TECHNICAL NOTE

WINGS NURSERY, LIDSEY ROAD, WOODGATE, WEST SUSSEX

Response to West Sussex County Council Highway Comments.

Ref: ADMA/17/3711s

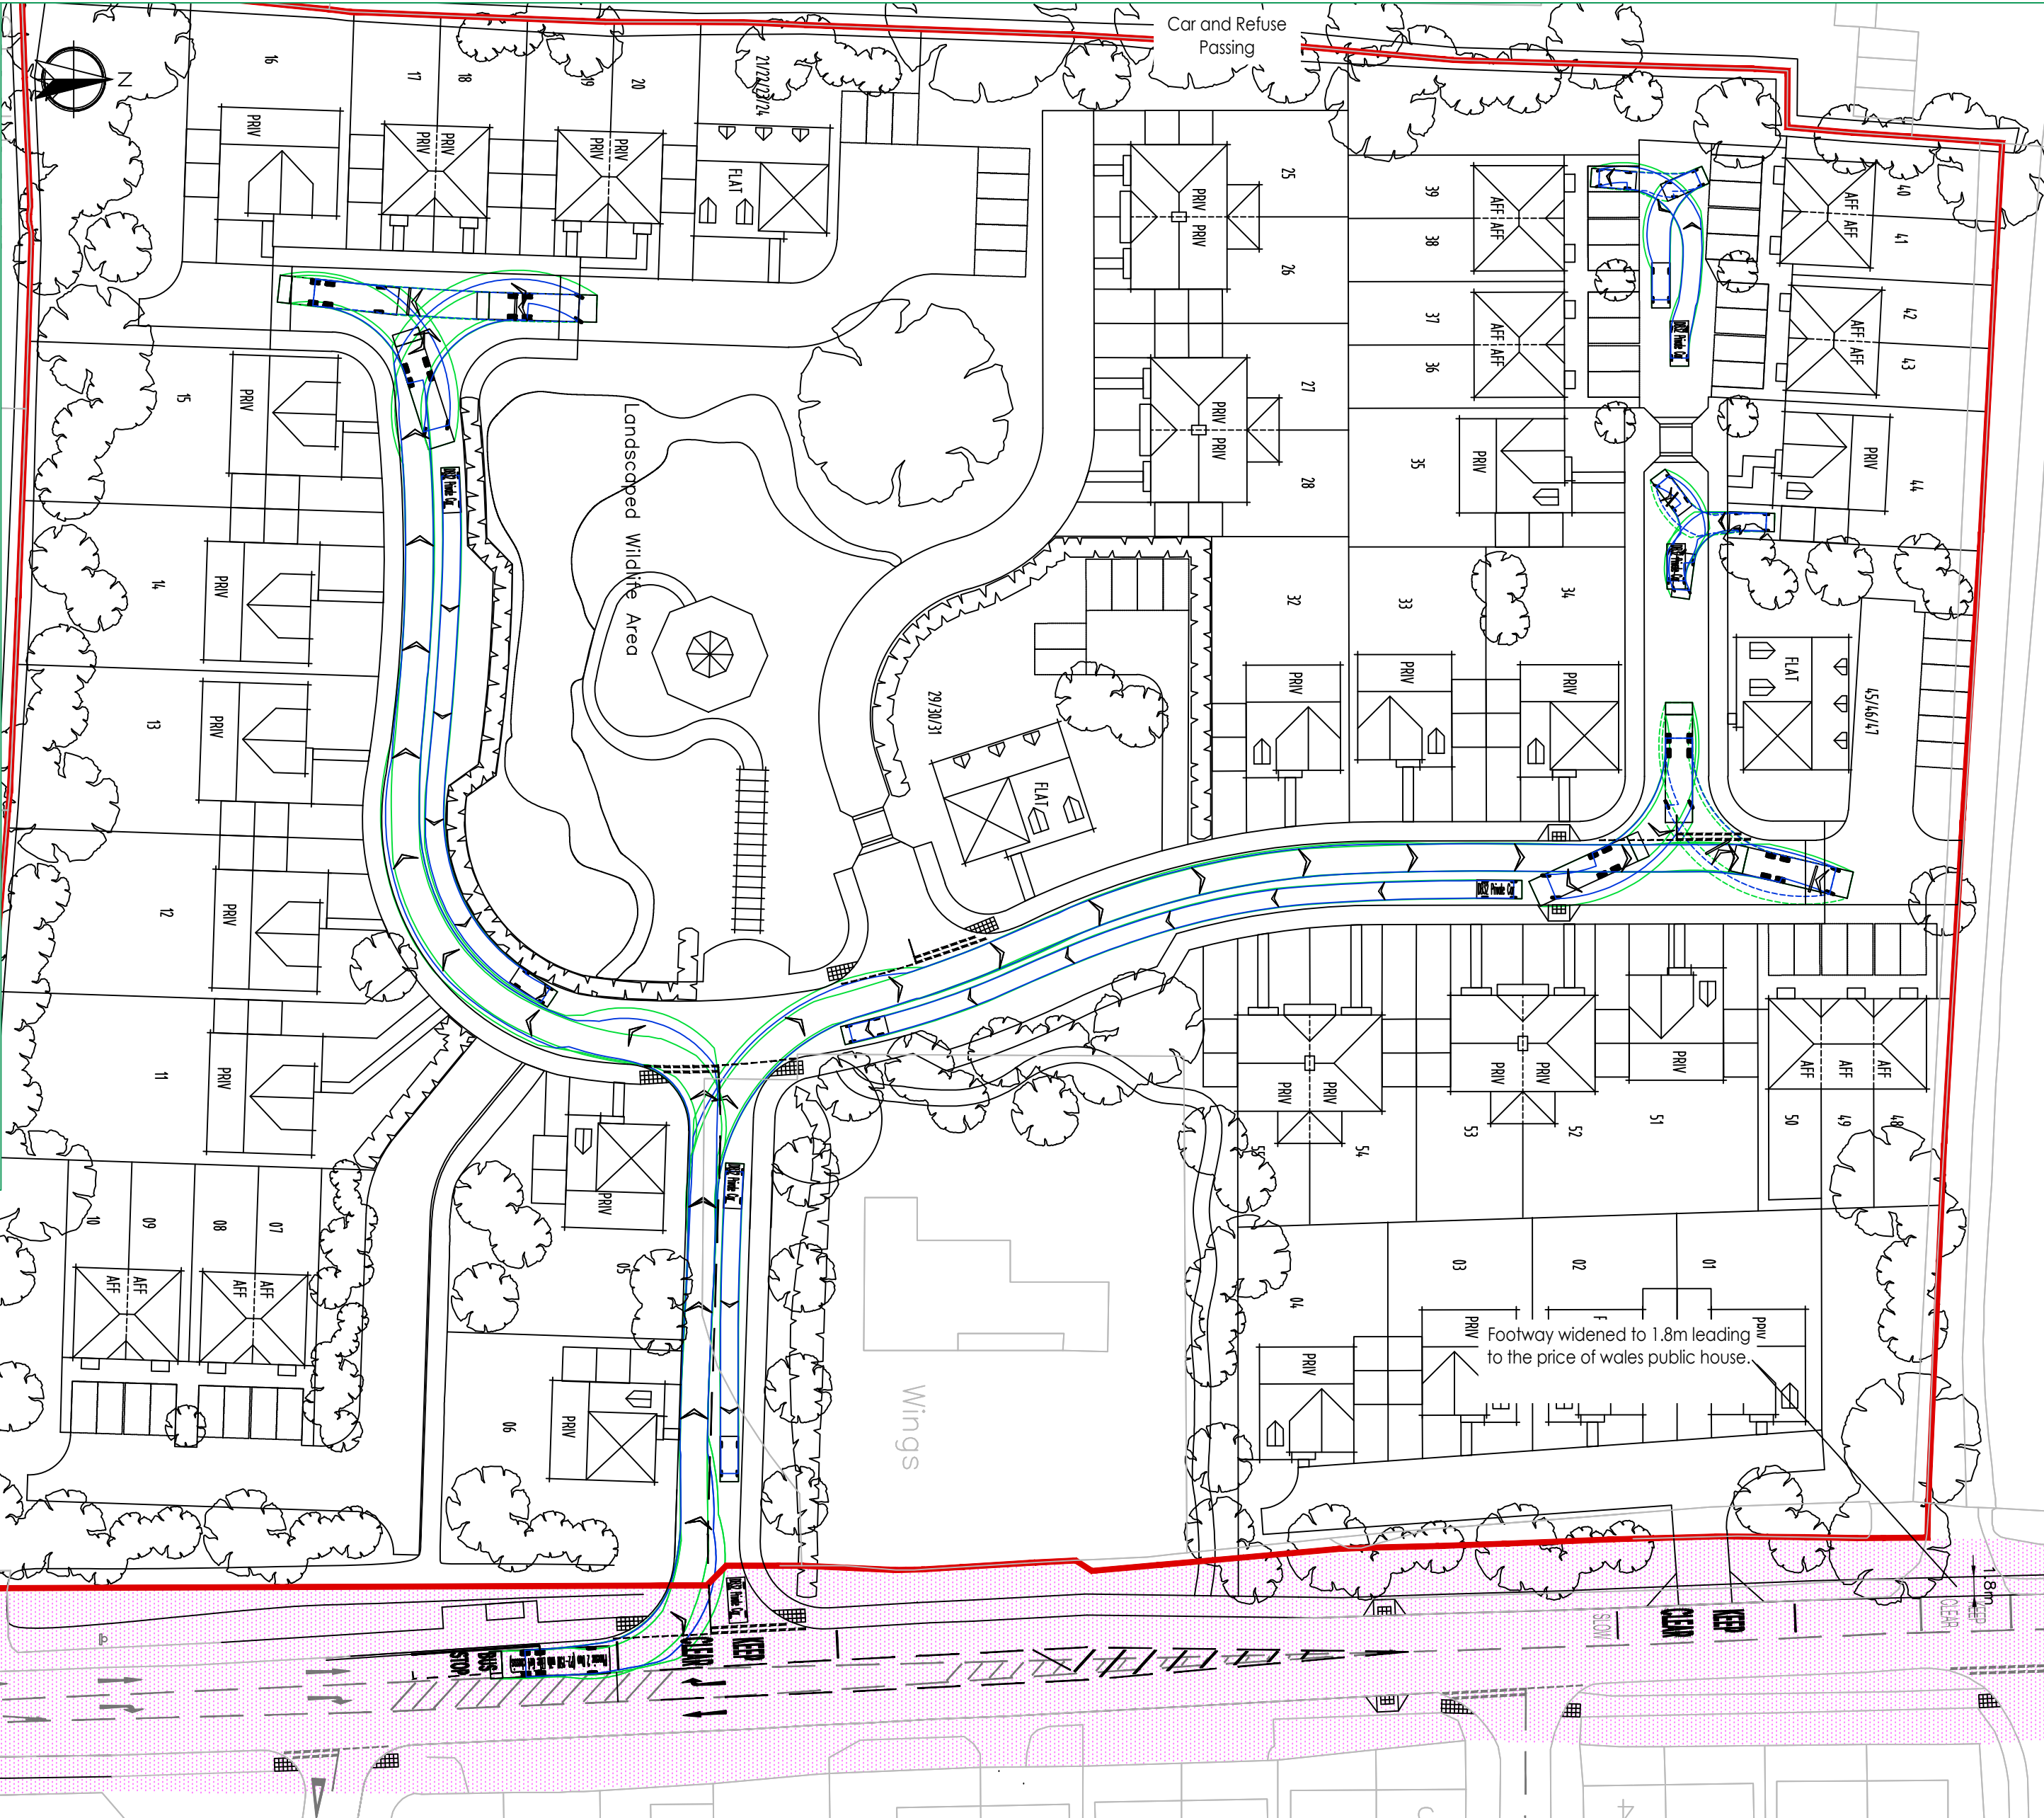
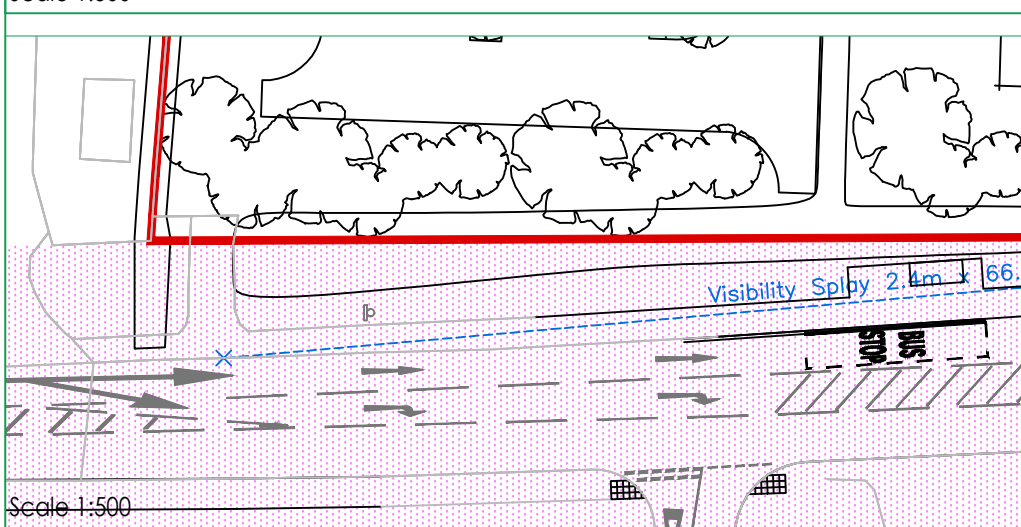
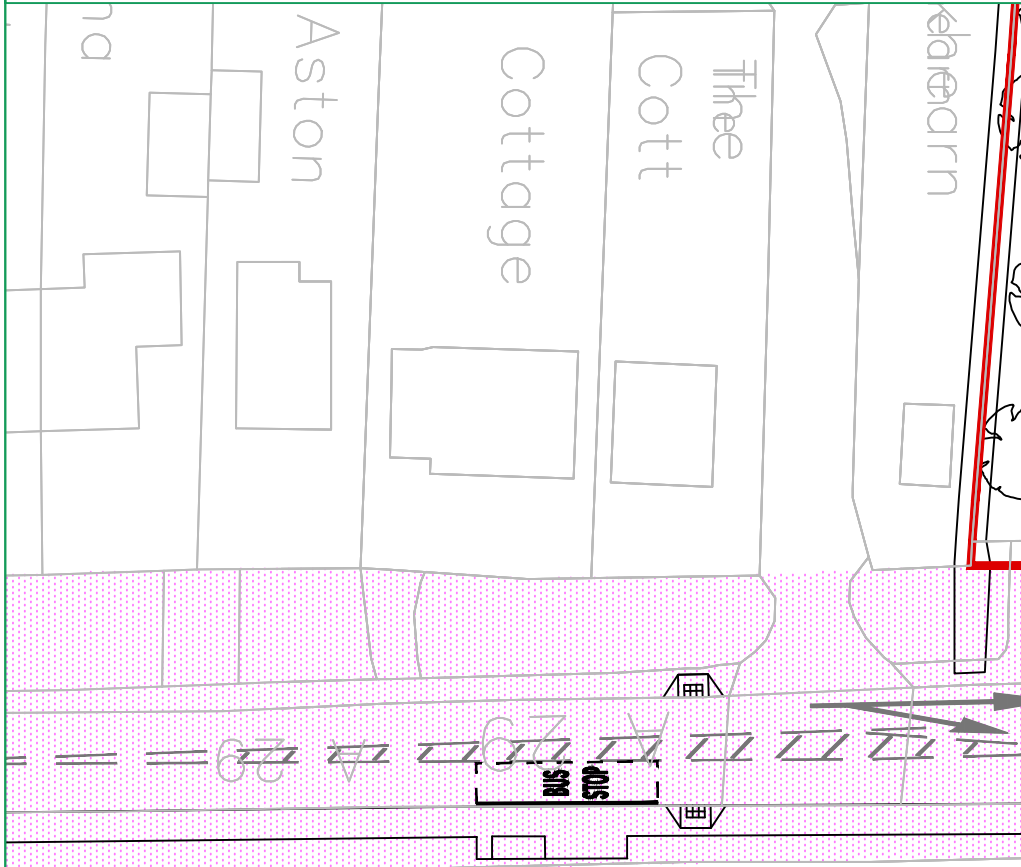
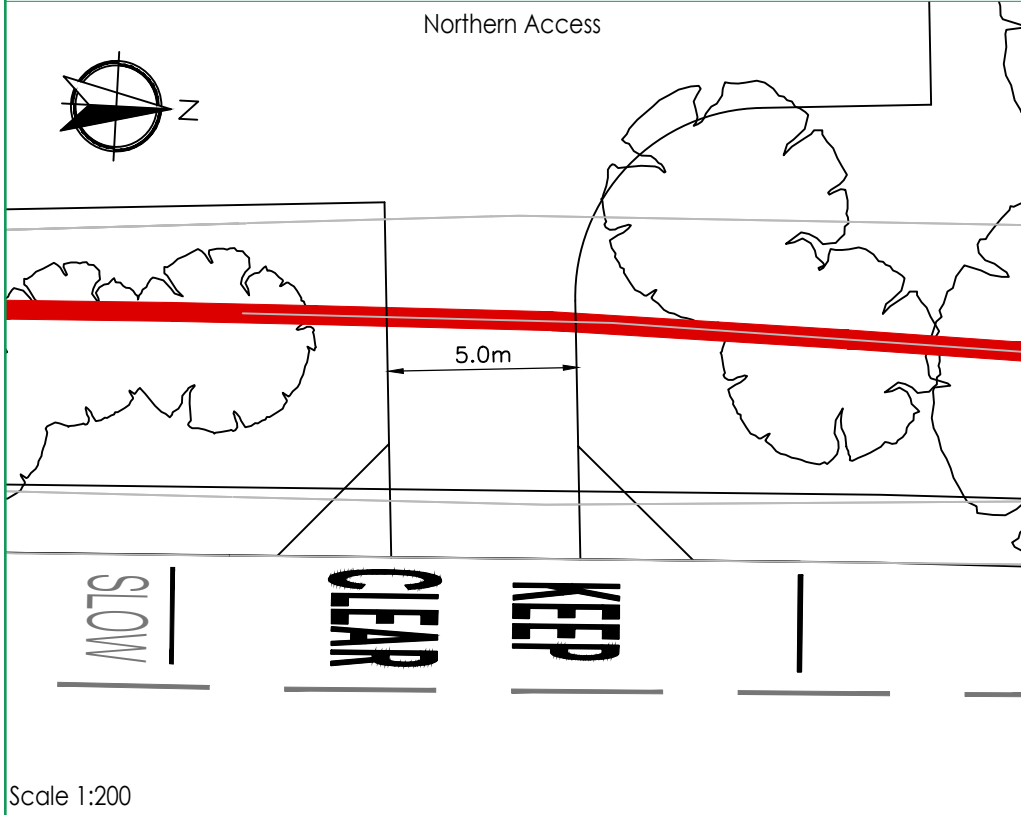
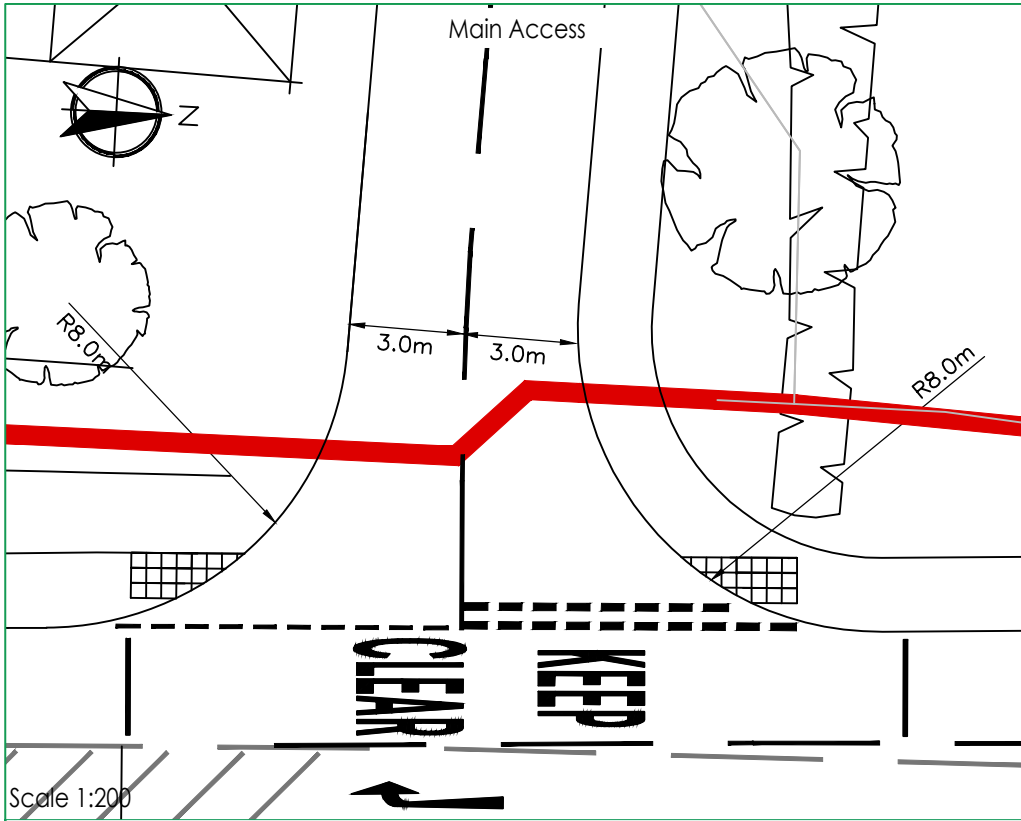
The proposed access arrangements comprise two junctions – one serving 4 dwellings in the form of a shared private drive with the other one a more formalised road junction with footways running either side. The latter (referred to herein as the 'primary access') has a single lane approach to the A29 Lidsey Road. Residents of the new estate, when emerging, would have to wait at the junction to turn left (northbounds) out of Woodgate Close onto the A29 if a queue of traffic resulting from the railway crossing prevailed. Only when such queuing dissipated, could drivers easily emerge. Drivers wanting to turn right (southbounds) might experience frustration being blocked by the left turners and/or traffic queue. In such circumstances it is likely that right turning drivers may choose to circumvent the waiting driver and use the opposing lane at the junction. This has been observed at Woodgate Road and neighbouring roads. This increases the safety risk should any vehicle co-incidentally be turning into the junction from the A29. While the traffic impact appears modest given the number of dwellings proposed, any blocking-back would create delays leading to emerging vehicles queueing within the estate.

3. No 'KEEP CLEAR' markings shown on the A29 (although it is noted that the Stage 1 Road Safety Audit supplied with the application makes mention of this). Although this might – in part - assist with attempting to overcome the issues raised in 1 and 2 above, it would not fully resolve the issue.

- 2.2 It is consider unlikely that this manoeuvre would be ordinarily attempted and therefore not a material safety concern. Highways design cannot take account for anomalous driving behaviour. The PIA incident data reveals a single incident associated with a similar manoeuvre, this is however a standalone incident that cannot be considered statistically significant. To enable right turns out of the site and avoid any perceived issues associated with potential flow restriction we have shown a right turn exit lane in the attached drawings.

- 2.6 The recommended measures within the Stage 1 Road Safety Audit have been accepted and changes accordingly made to the access as demonstrated in the attached drawings.

- 2.10 The recommended measure in the Stage 1 Road Safety Audit has been accepted and identified in the attached drawings.
